MECKLENBURG COUNTY
Park and Recreation Department

MEMORANDUM

DATE: April 18, 2024

RE: Rezoning Petition #2024-029
PID# 02506206

TECHNICAL DATA SHEET

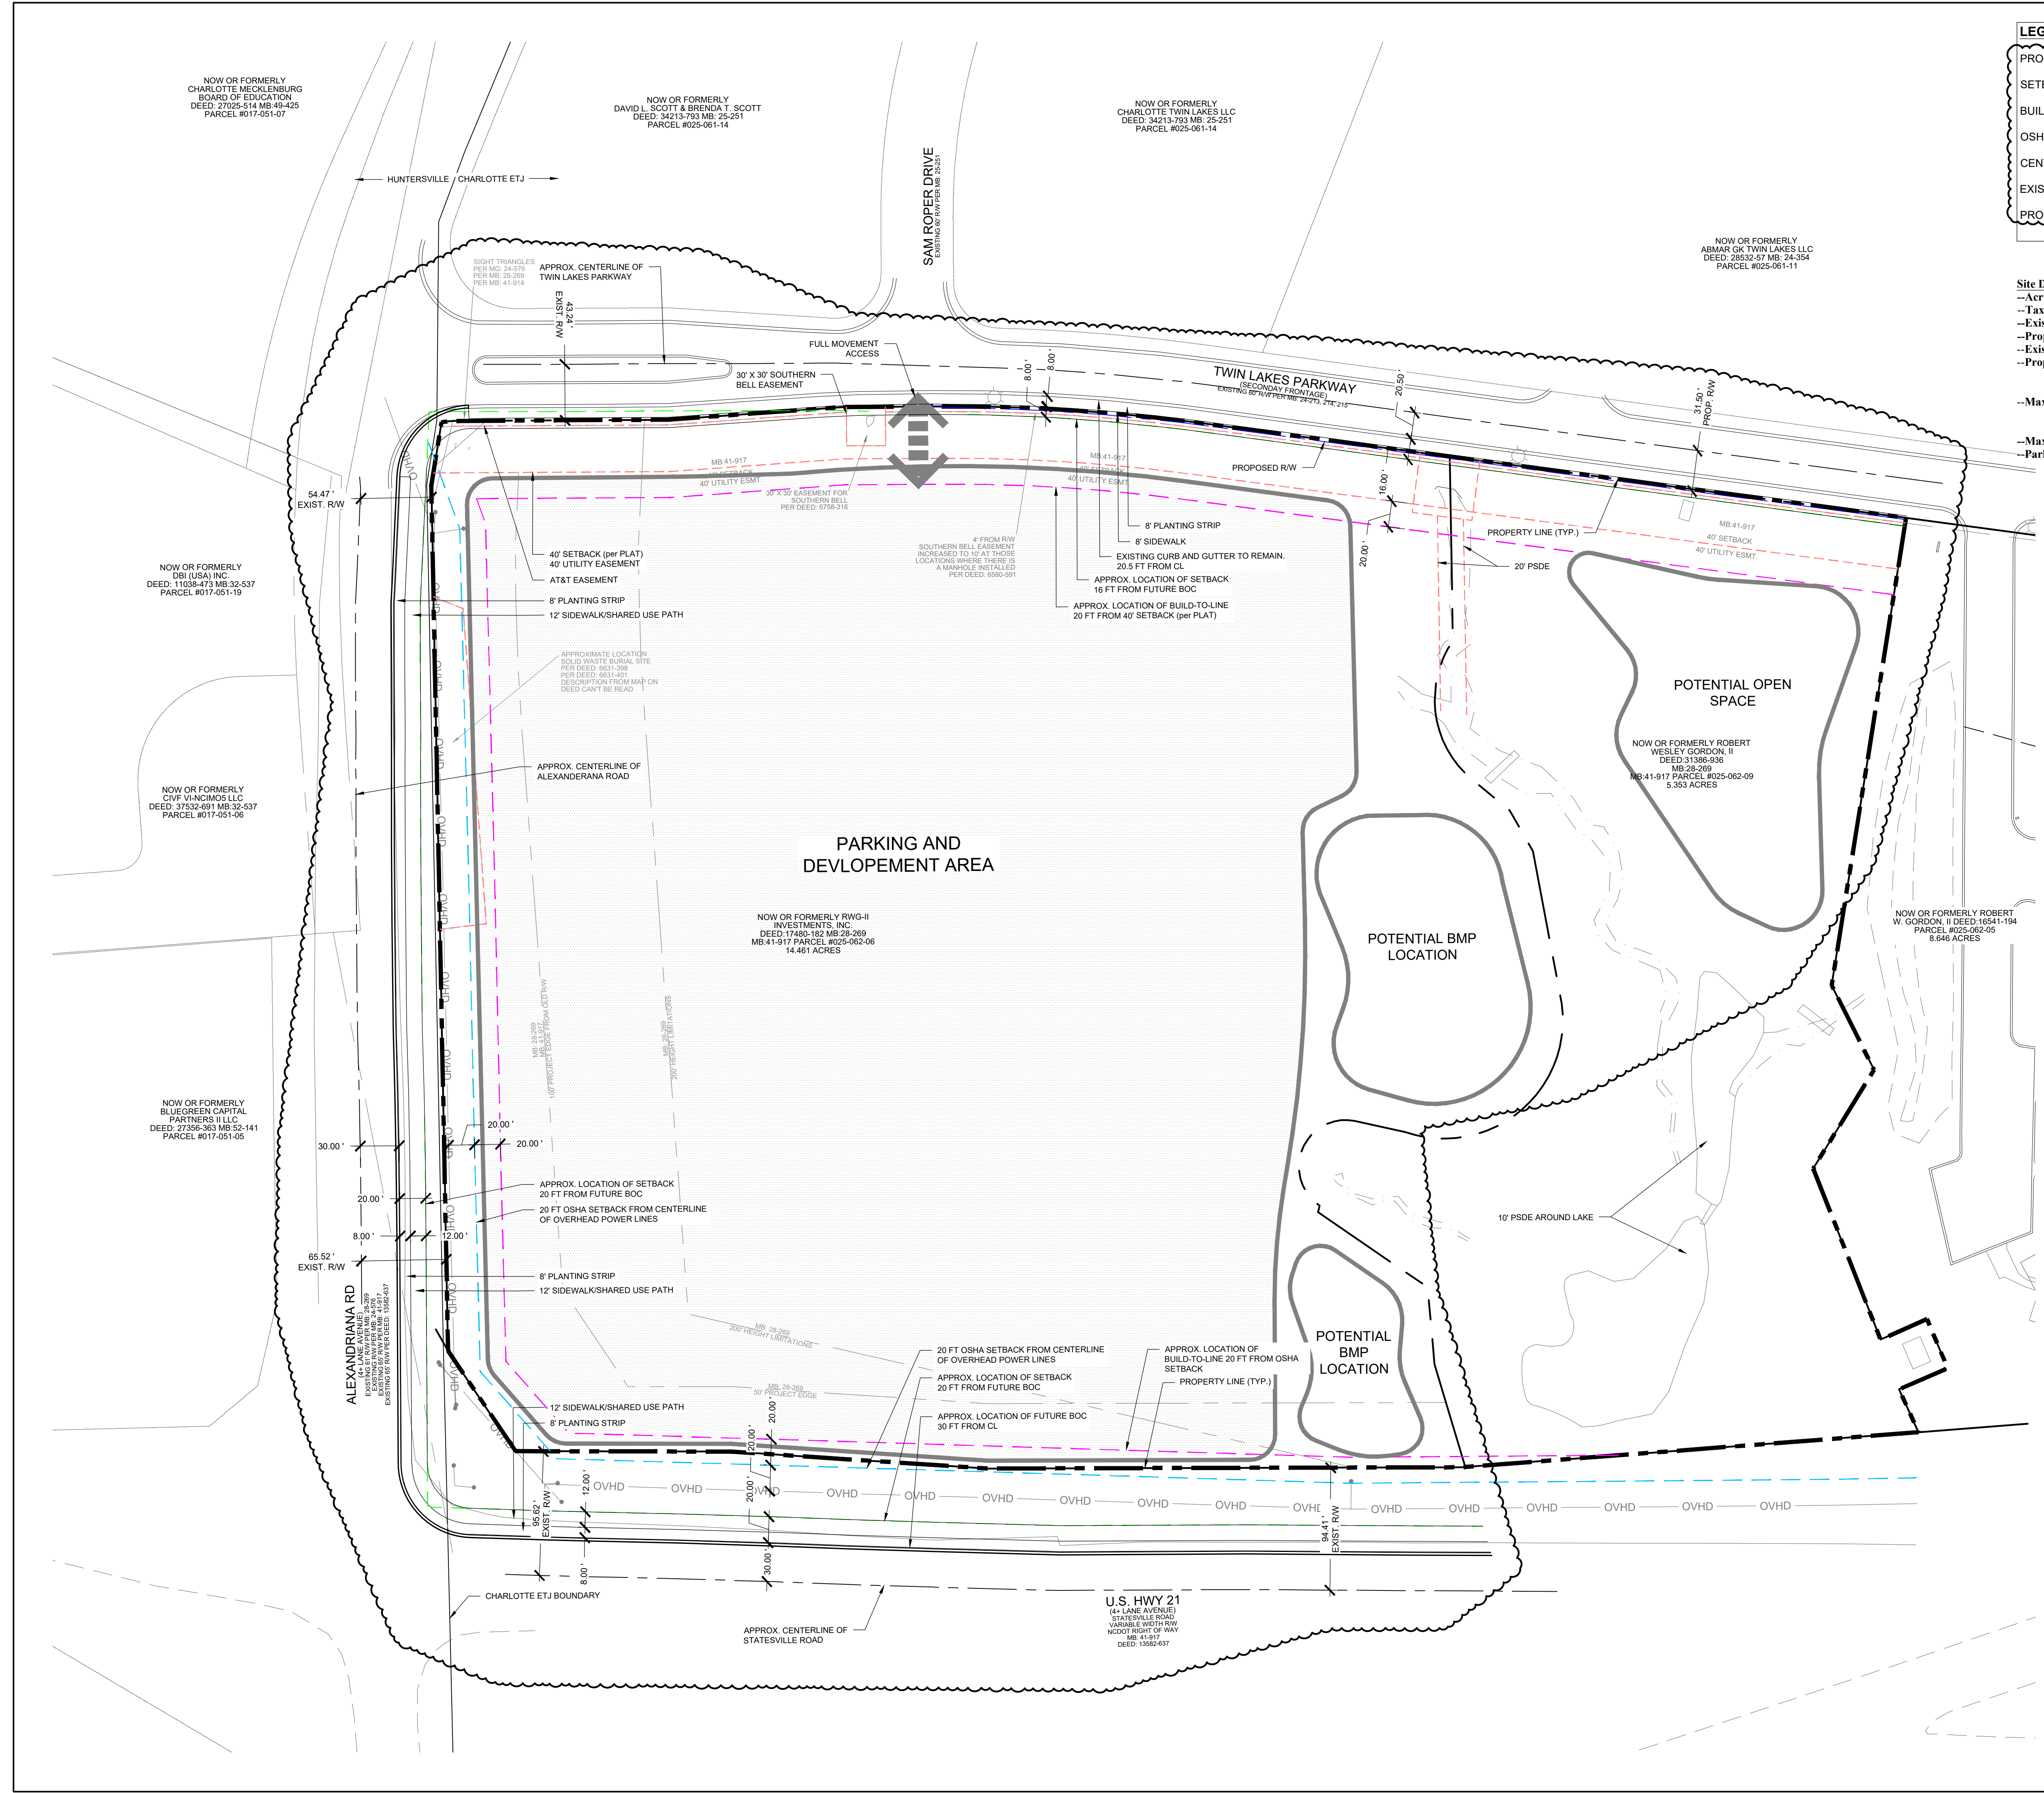
MCPR requests a minimum of **1.0** acres to be dedicated and conveyed to Mecklenburg County for a future neighborhood park. This requested park land shall be adjacent to a public right-of-way for access and is conducive for the development of the typical amenities found in a neighborhood park and cannot include tree save parcels or stormwater BMP's.
